COUNTY COUNCIL'S RESPONSE TO CONSULTATION ON THE FOLLOWING DEVELOPMENT PROPOSAL

Application No: 17/02534/OUT

Proposal: OUTLINE - The construction of a business park of up to 60,000 sq.m (GEA) of flexible Class B1(a) office / Class B1(b) research & development floorspace; parking for up to 2,000 cars; and associated highways, infrastructure and earthworks

Location: Land North Of Bicester Avenue Garden Centre Oxford Road Bicester

Drawing:
170211-02

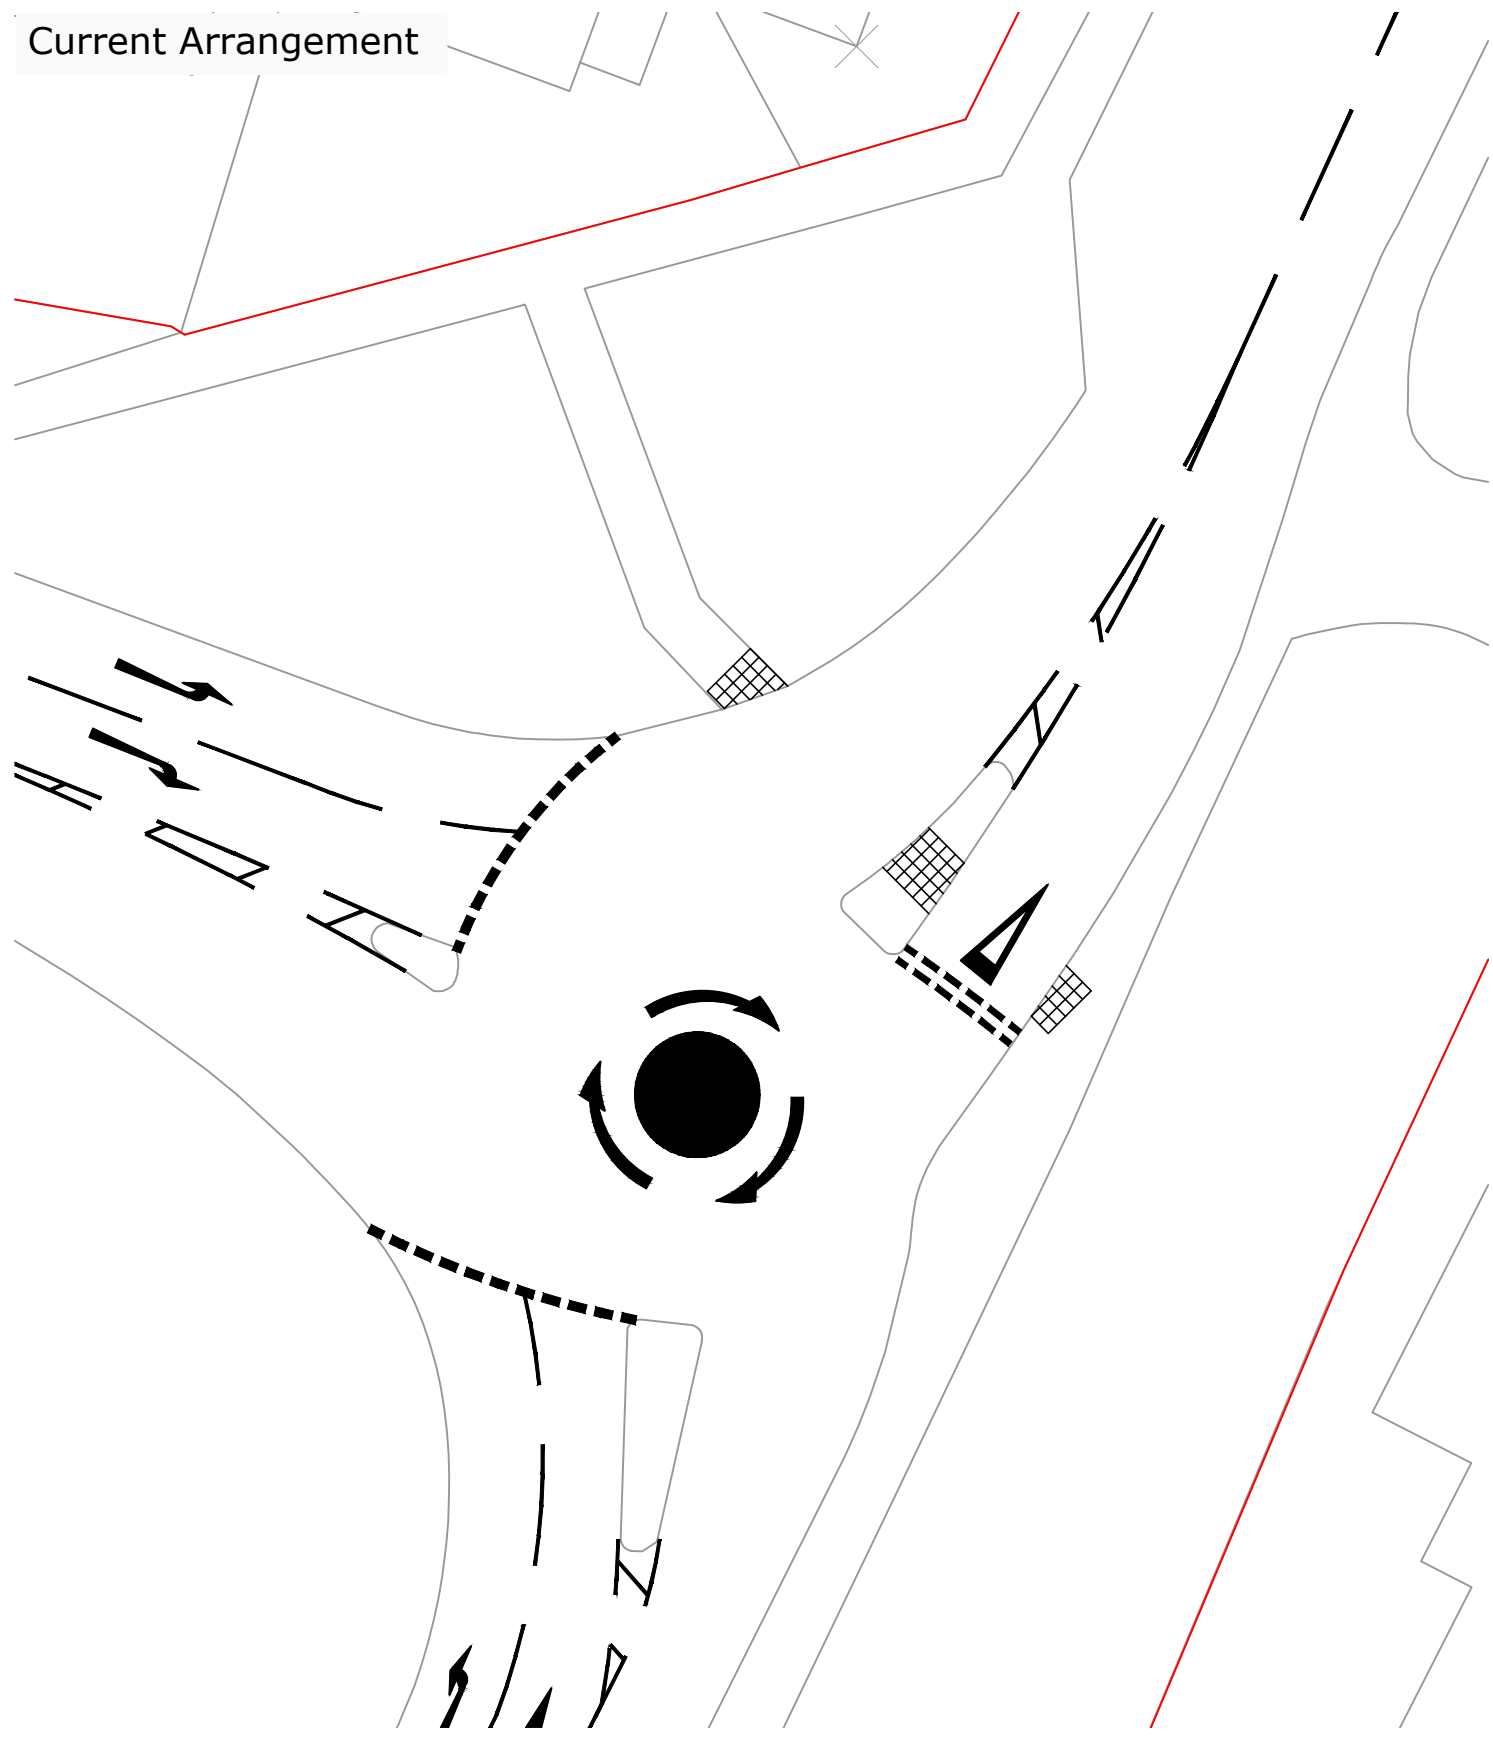
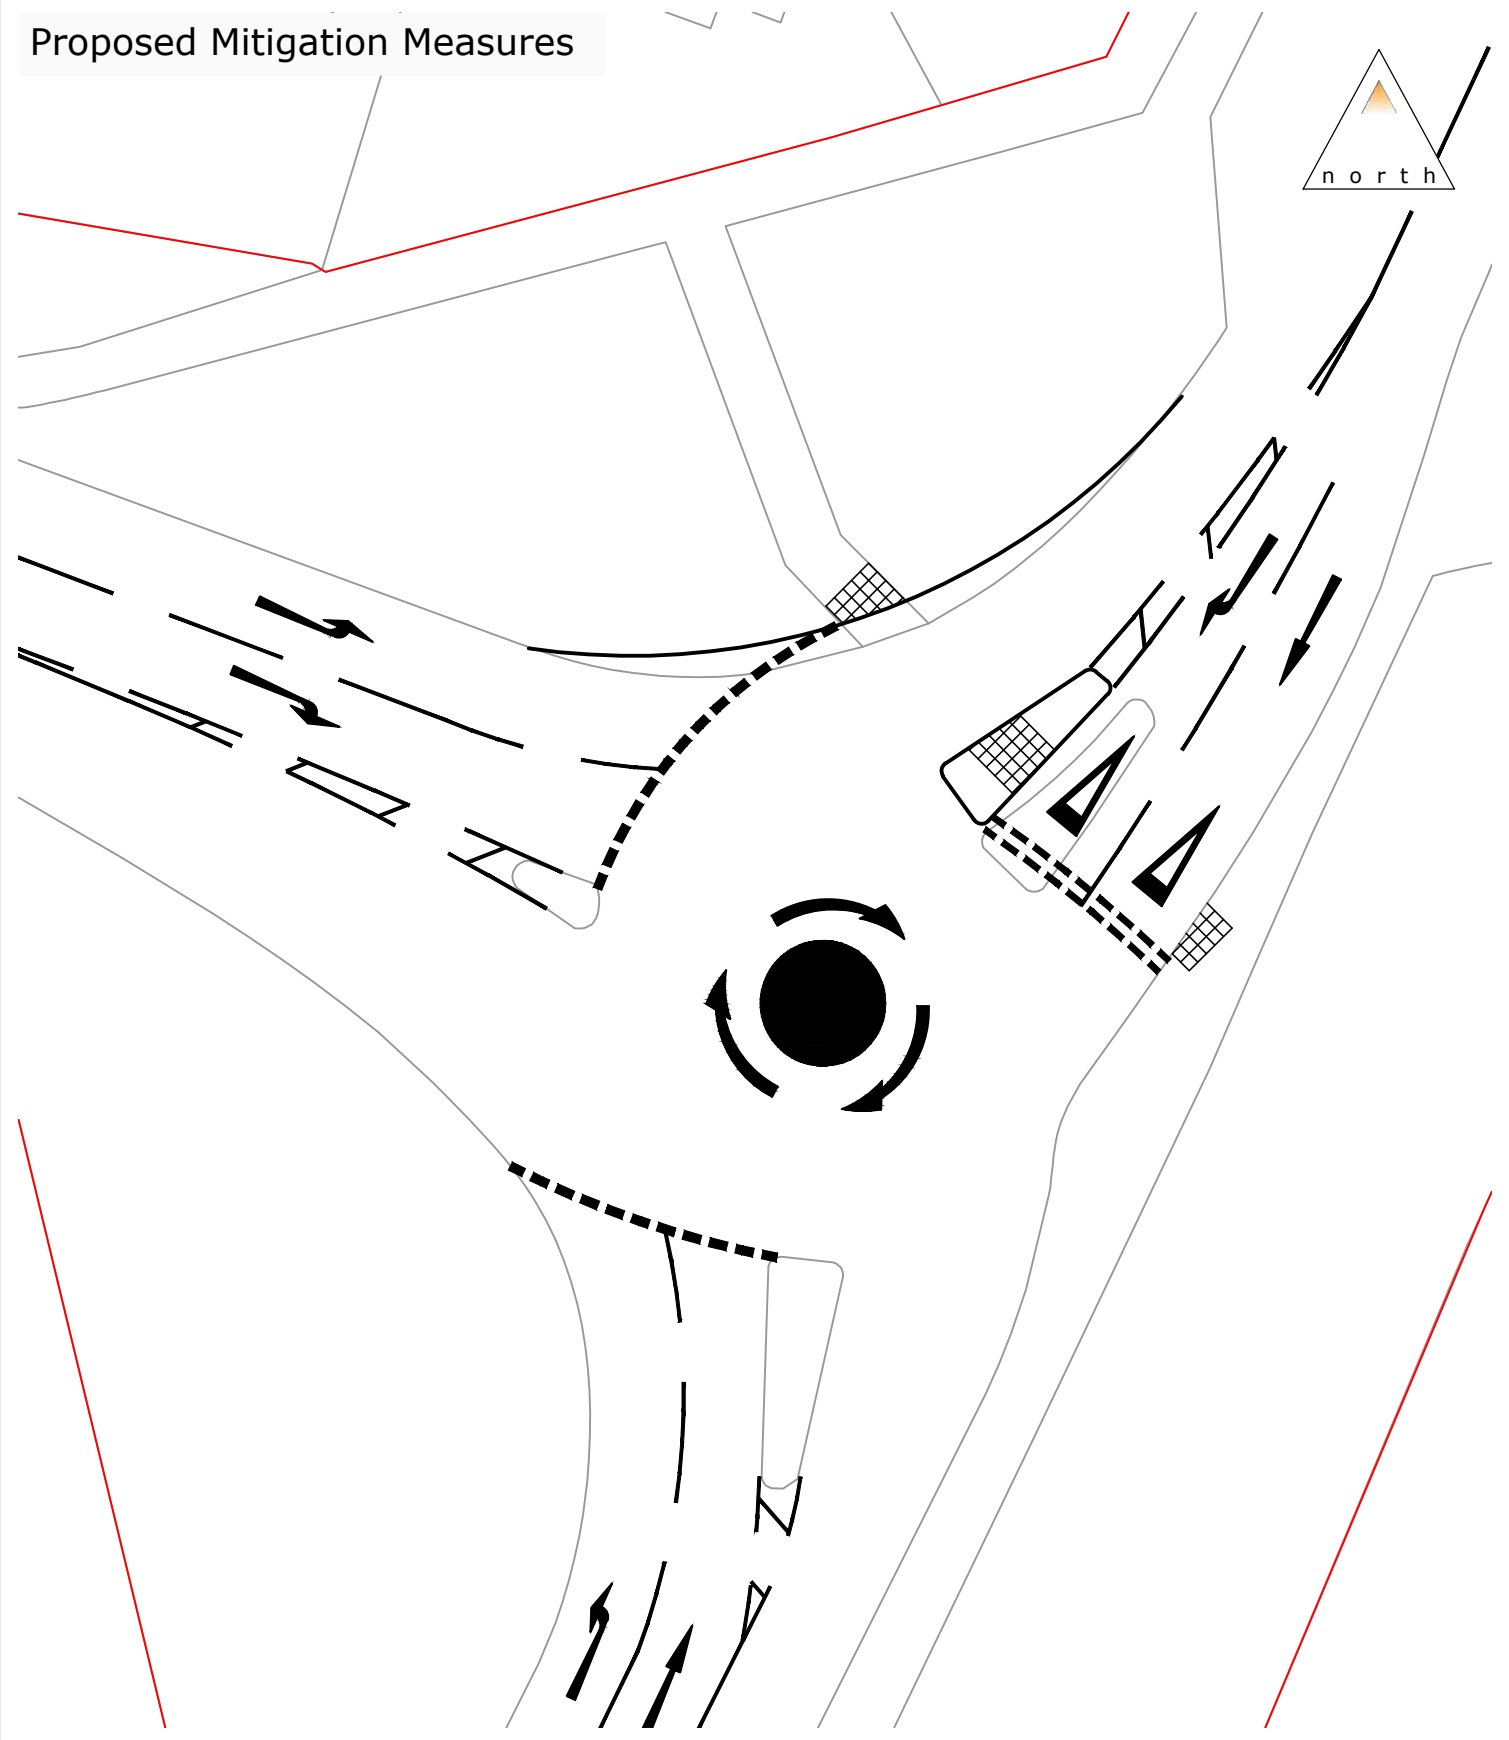
The highway mitigation arrangement proposed in **Drawing 170211-02** presents a number of design issues that I consider would increase safety risk on what is already a very busy section of A41 Oxford Road. Observed notably are;

- The scheme proposes to include an additional right turning lane from A41 Oxford Road into Lakeview Drive. Lakeview Drive currently has a single flow-in lane from the northbound A41 traffic. Although the scheme attempts to create an additional flow-in lane at its mouth, lane continuity is unclear. The presence of the triangular island pedestrian refuge between the A41 Oxford Road (SB) and Lakeview Drive prevents a balance between the exit and entry lanes. The number of straight ahead entry and exit lanes for a traffic stream should be balanced to reduce conflict caused by traffic merging or diverging within the junction intervisibility zone. Where it is necessary to reduce the number of lanes on the exit arm this should be carried out beyond the junction intervisibility zone, over 100 metres for a single lane reduction, measured from the limit of the junction intervisibility zone, according to Figure 2/11 of Design Manual for Roads and Bridges (Vol 6 Sec 2, Part 3 TD/04). **(Reason for objection)**

- No vehicle tracking has been provided to demonstrate safe passage of the vehicles particularly on the turn in and out of Lakeview Drive. With the significant narrowing of carriageway lanes along the A41 Oxford Road and

bearing in mind that Lakeview Drive also serves as access to Tesco deliveries, the application must demonstrate by tracking analysis that gives consideration to long and articulate vehicles besides cars that they can reasonably use the junction. **(Reason for objection)**

- The current A41 Oxford Road layout requires some motorists to change lanes over very short distances. With the development proposing to add lanes on top of what is in existence, that leaves me concerned that this would likely lead to increased conflicts in the immediate vicinity of the development. In the event that the proposed highway works requiring carriageway widening along the A41/Oxford Road are agreed, these should be carried as per OCC specifications. We would require the surface course in the adjacent area / lane to be replaced with a stepped joint in the layers below as illustrated in drawing **HSD 700/025** via <https://www.oxfordshire.gov.uk/cms/content/highway-standard-details>

- The mitigation layout plan is not scaled to enable a comprehensive review of the dimensions of the proposed highway. **(Reason for objection)**
- *Triangular island pedestrian refuge* – Pedestrian refuges and traffic islands help pedestrians by enabling them to deal with one lane or direction of traffic at a time. This appears to be significantly reduced, and I would like to be certain that this is deep enough to accommodate a reasonable number of pedestrians including bicycles and/or a wheelchair – noticing that this is a busy intersection likely to be used by platoons of pedestrians such as at peak times.
The central reservation – The proposed scheme also intends to significantly reduce the width of the central reservation along the southern arm of the A41 Oxford Road. In its existing layout the A41 Oxford Road ranges between 4.2m- 6m in width. A further reduction in width shall likely make it impossible for erection of the associated street furniture such as signage, lamp posts and traffic signal posts. These structures are accommodated within highway land between/adjacent to carriageways and it is required that any placement of such posts should be clear by 0.45m from any face of the kerb. The proposed layout does not appear to have given consideration for this. It goes without need to say that such a busy section of highway shall require significant signage and traffic signal heads to give information to motorists and control traffic respectively.

Such significant highway changes need to be accompanied by a Stage 1 Safety Audit as part of the application.
